KITTITAS COUNTY

DEPARTMENT OF PUBLIC WORKS

MEMORANDUM

TO: All Staff
FROM: Public Works Planning Review Team
DATE: March 5th, 2020
SUBJECT: BL-20-00005 Conner

PART OF SECTION 10,  
TOWNSHIP 20 NORTH, RANGE 16 EAST, W.M.

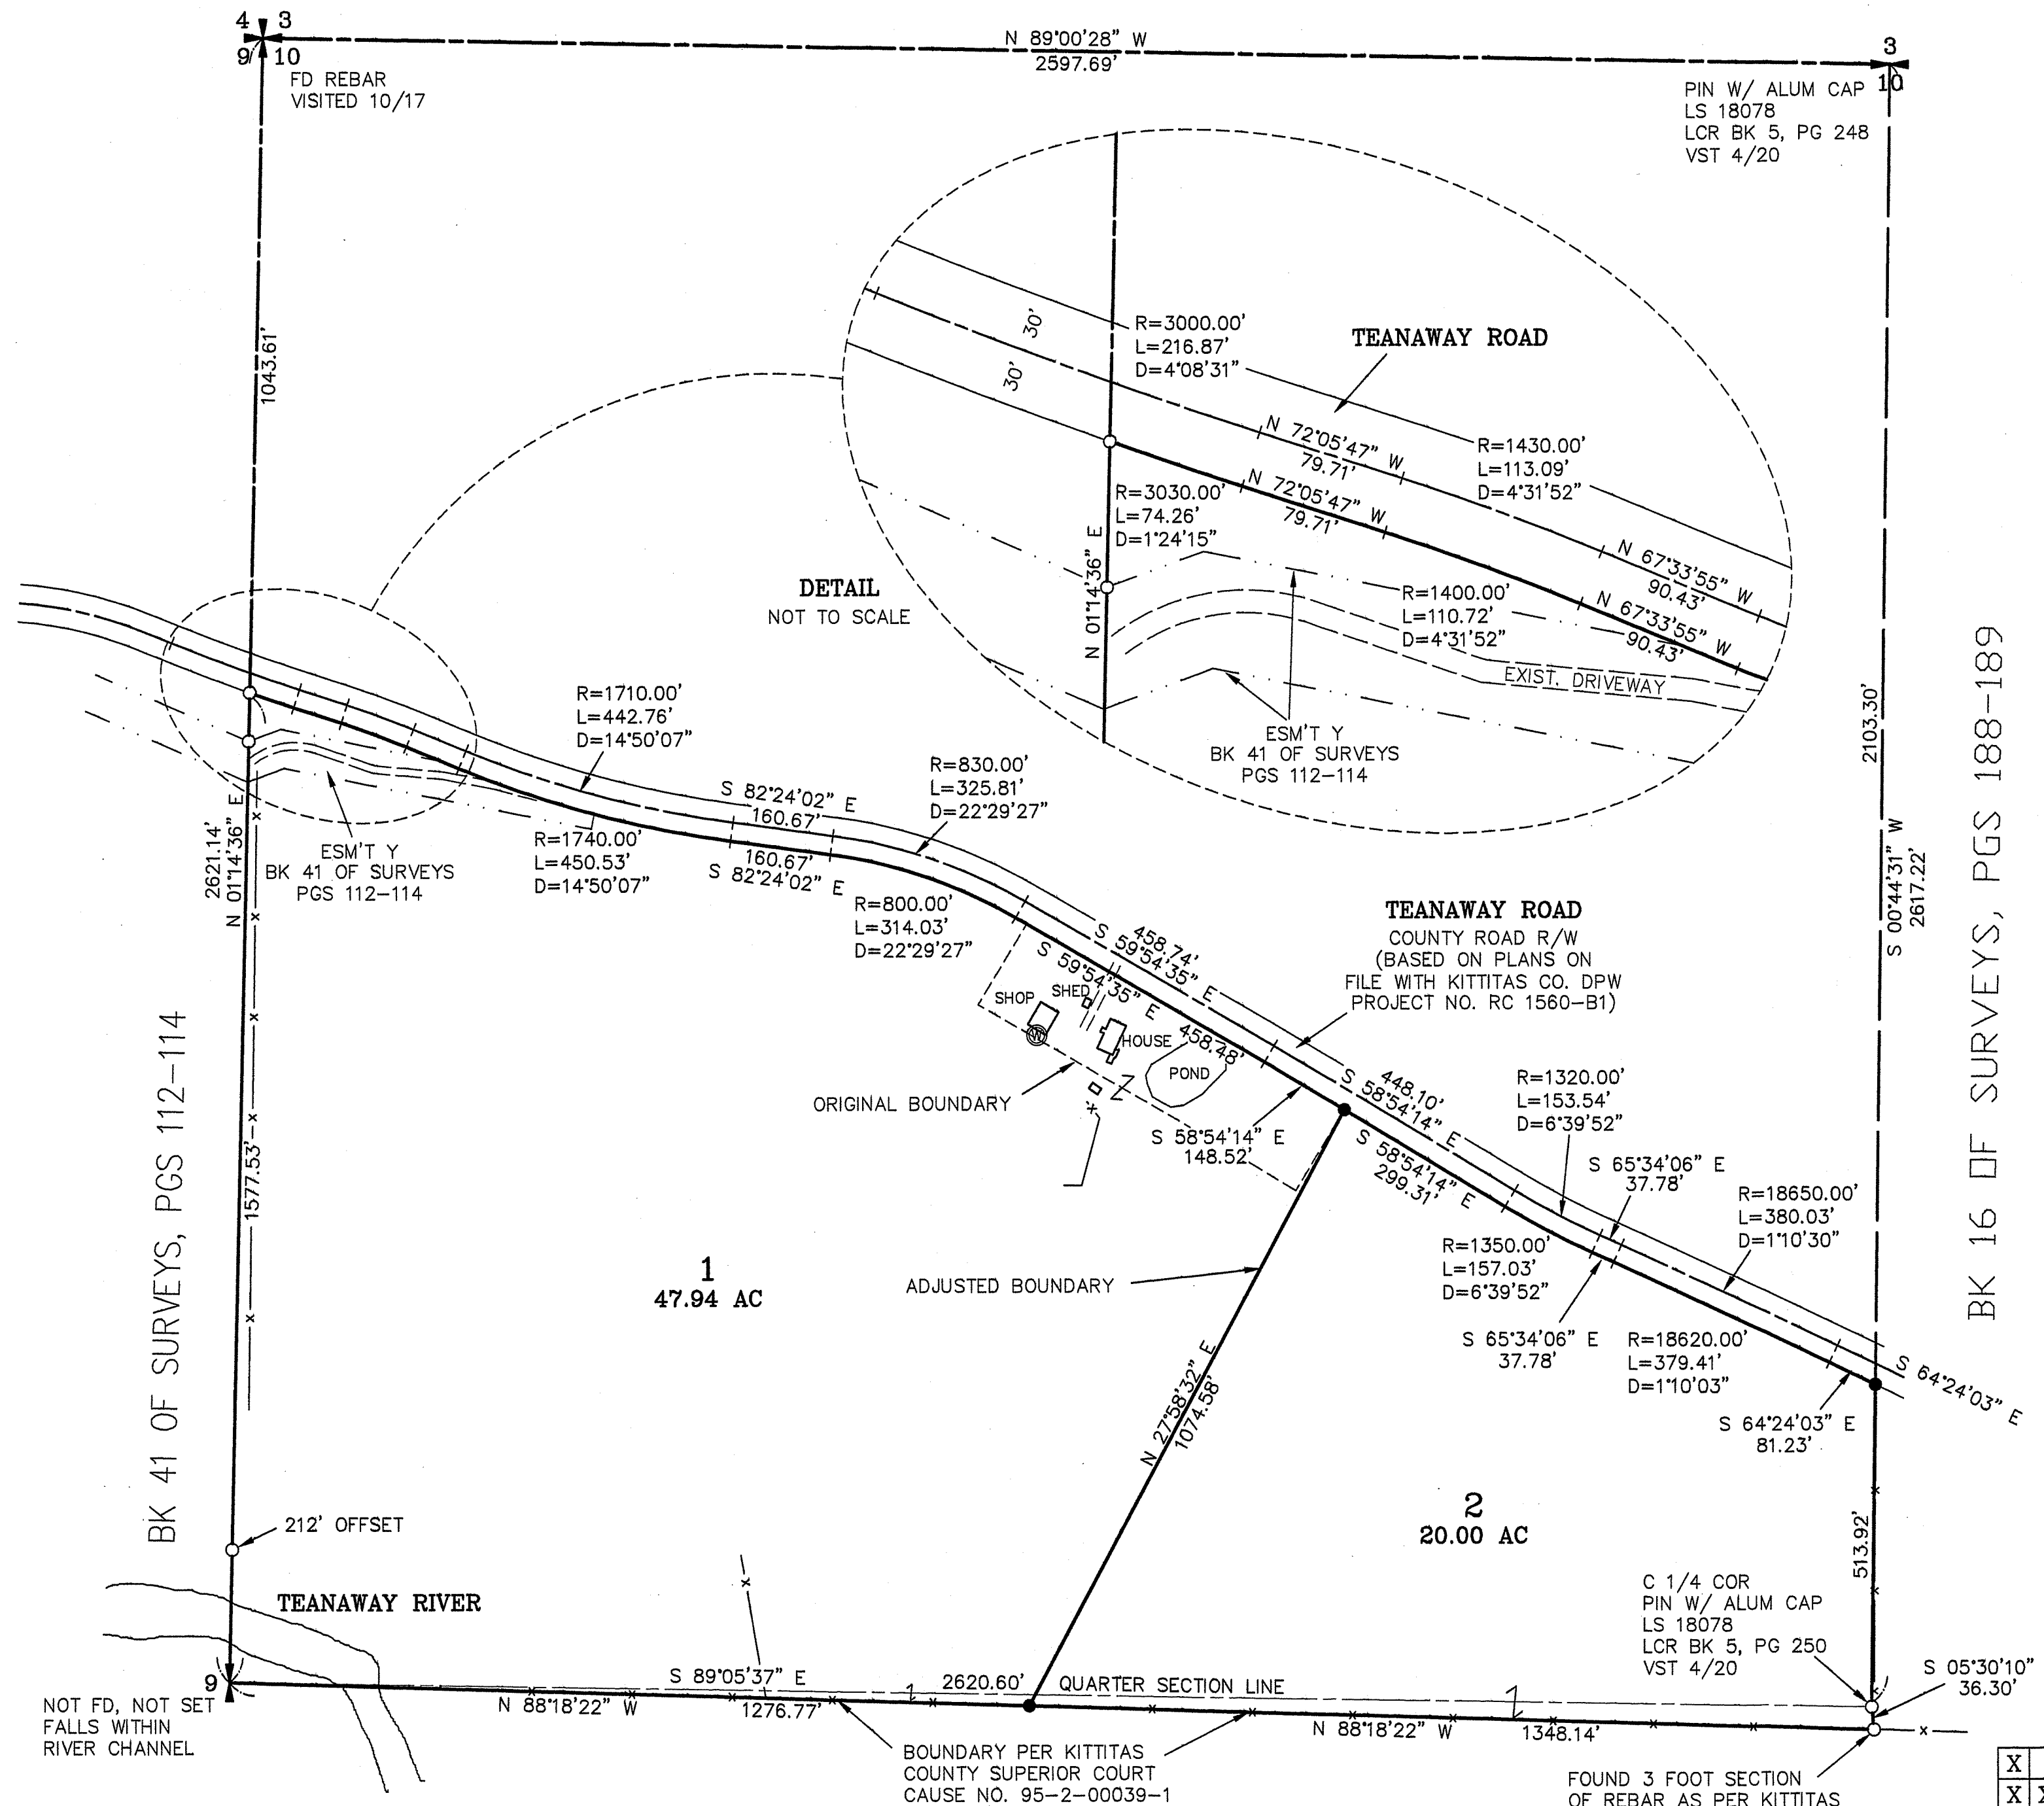
1. A revised legal description that describes the final configuration of the subject property shall be required.
2. A survey map for review. Any comments on the survey map will be reserved until final.
3. Show access easements on the face of the BLA

- a. An approved access permit shall be required from the Kittitas County Department of Public Works prior to creating any new driveway access or performing any work within the county road right of way.
- b. Any access easements shall be shown on the face of the BLA
- c. Maintenance of driveway approaches shall be the responsibility of the owner whose property they serve. The County will not maintain accesses.
- d. Any further subdivision or lots to be served by proposed access may result in further access requirements. See Kittitas County Road Standards.
- e. Evidence of existing access and/or evidence of access to be created should be confirmed prior to sale of property.
- f. Access is not guaranteed to any existing or created parcel on this application.
